**From:** [Graham Bowden](#)  
**To:** [Planning](#)  
**Subject:** RE: Planning Application Consultation 20/01122/COU  
**Date:** 08 October 2020 13:38:43

I have checked the Definitive Map for the East Drayton area and can confirm that East Drayton FP18 crosses the site edged in red on the 'site plan and pool enclosure' document (Drawing no P2009.02.001). I attach a plan showing the definitive route of the footpath and would be grateful if you could make the applicant aware of the legal line as there is no reference to the Public Right of Way in the application.

REF: 20/01122 East Drayton FP18

**SITE PLAN 1/250**

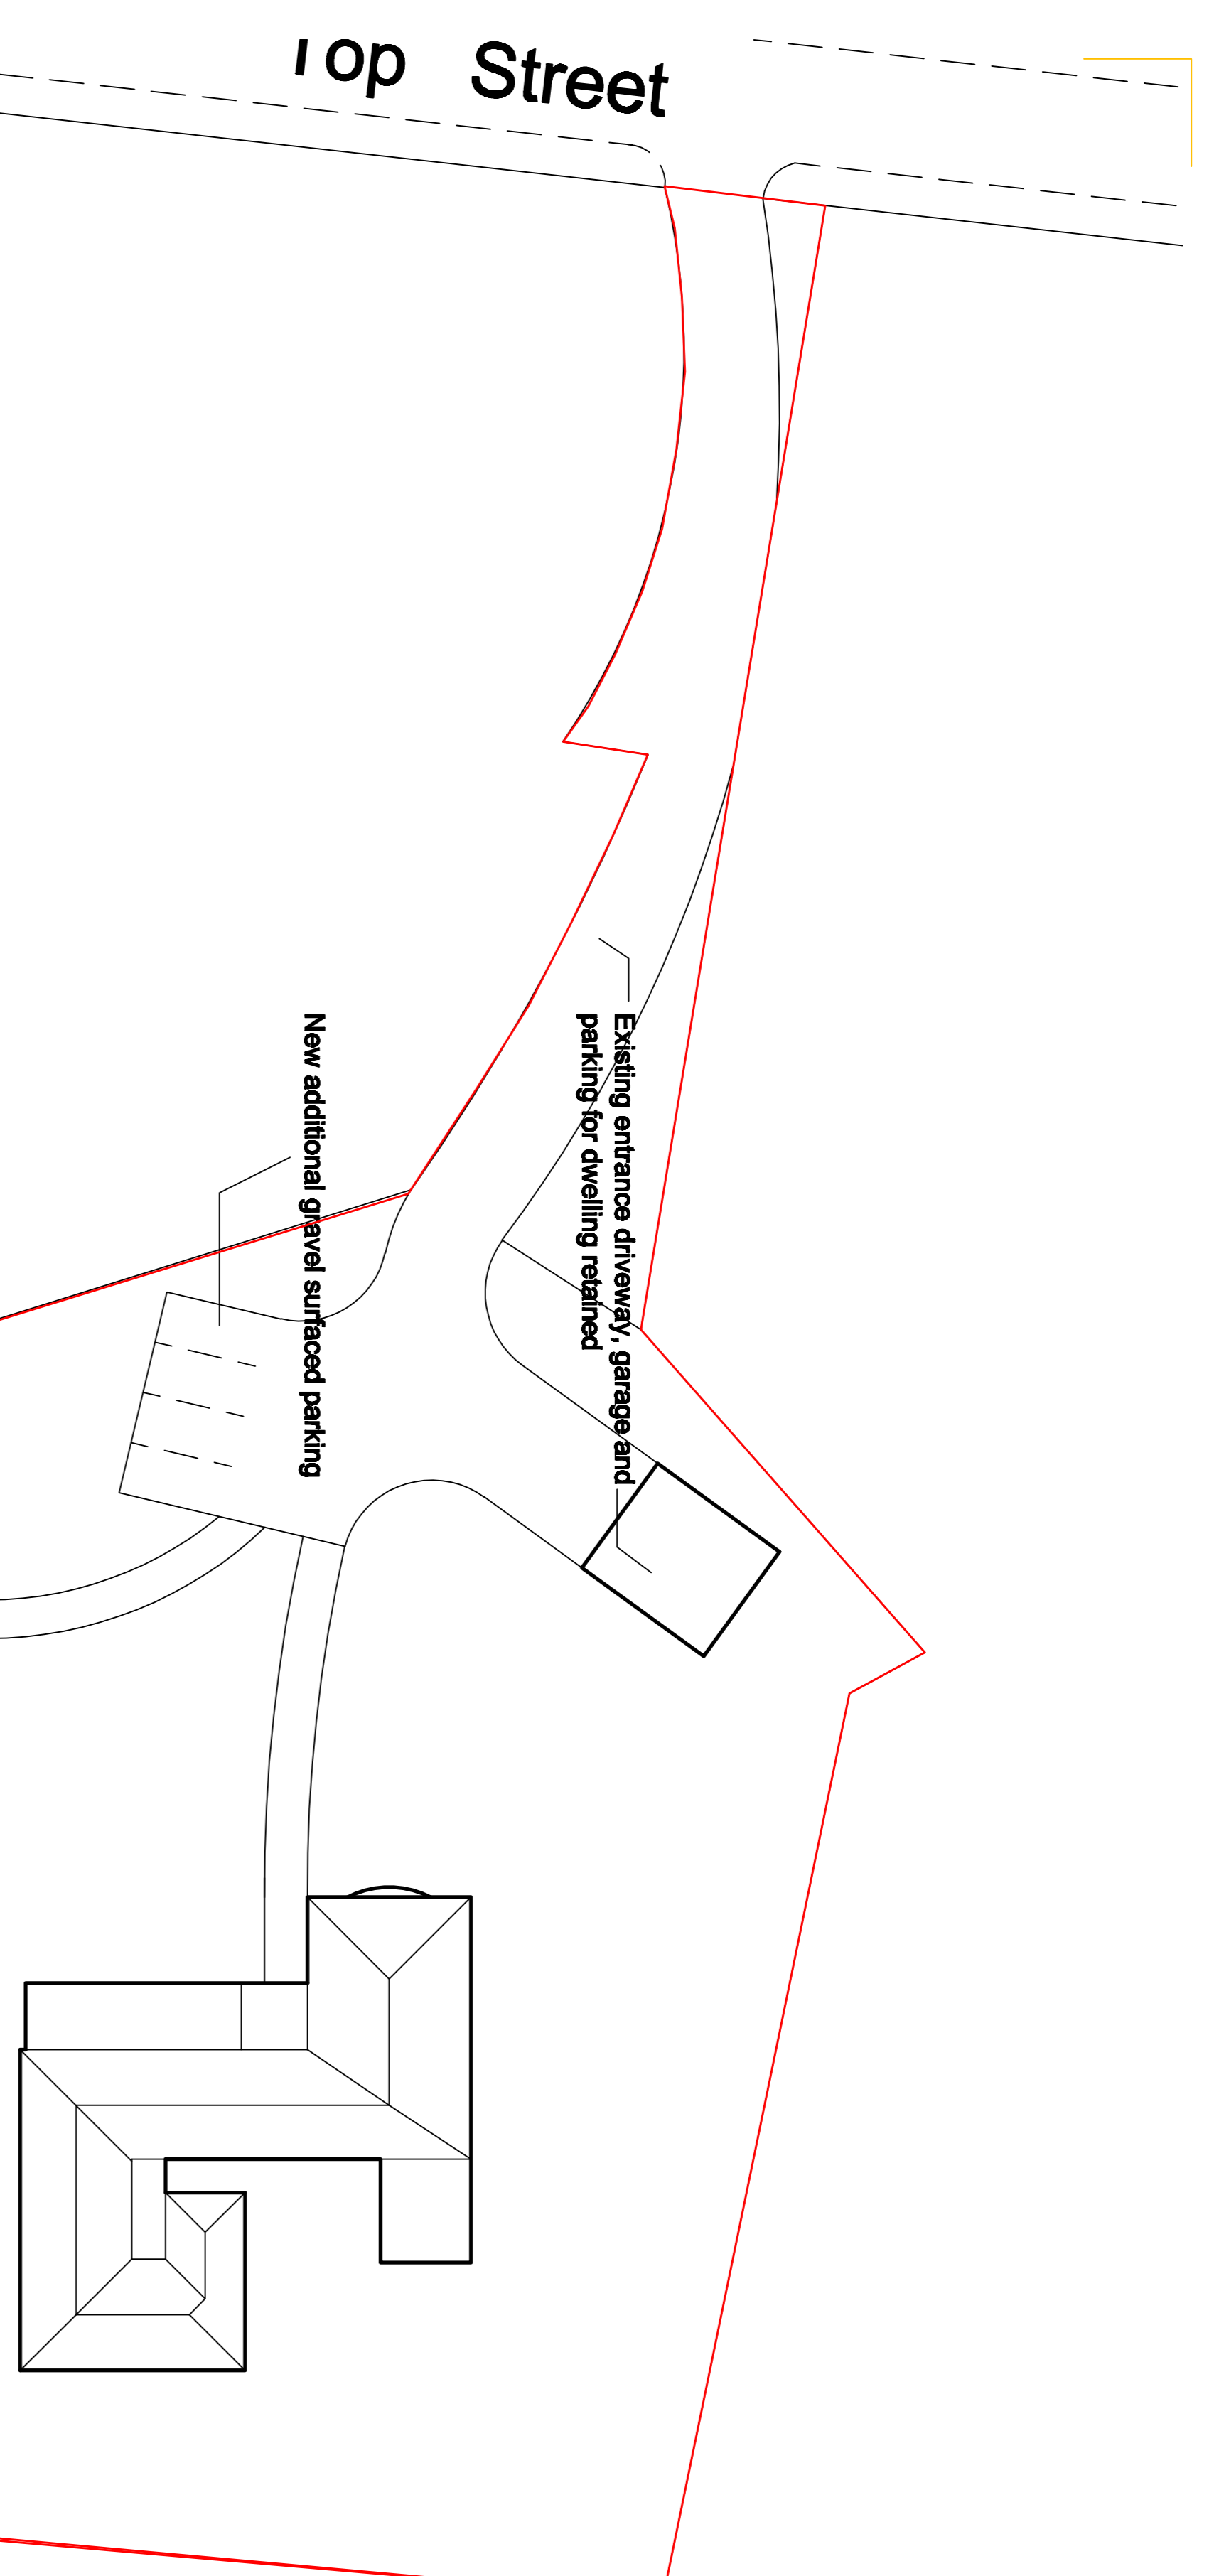
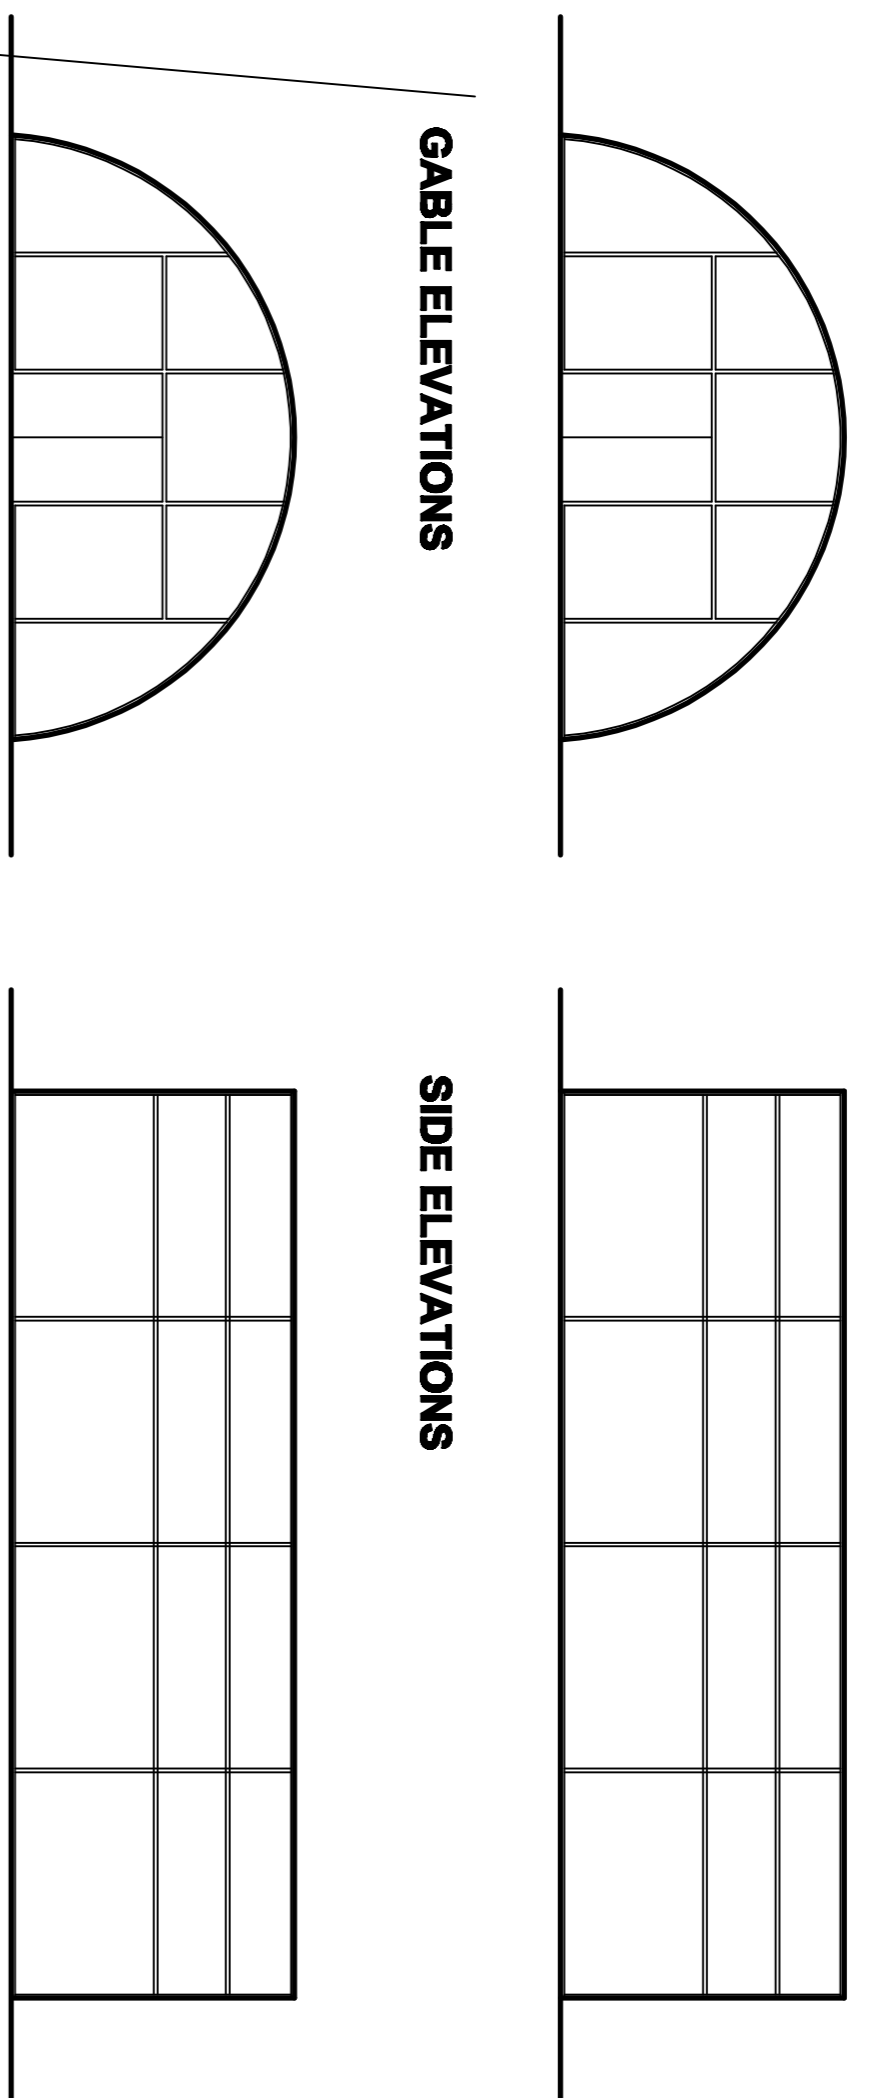
The proposed additional parking area within the planning application appears to impact on the legal line of the PROW and it is recommended that the applicant contact the ROW team to discuss an alternative location for the parking provision prior to the application being submitted. The increased traffic generated by the proposal would also affect users of the PROW, which follows the access route from Top Street and provision for users of the footpath should be considered.

We **object** to the proposed application on the grounds that the footpath is affected by the development and no provision has been made to accommodate it either in the design of the development or the acknowledgement of a Public Right of Way crossing land within the ownership of the applicant.
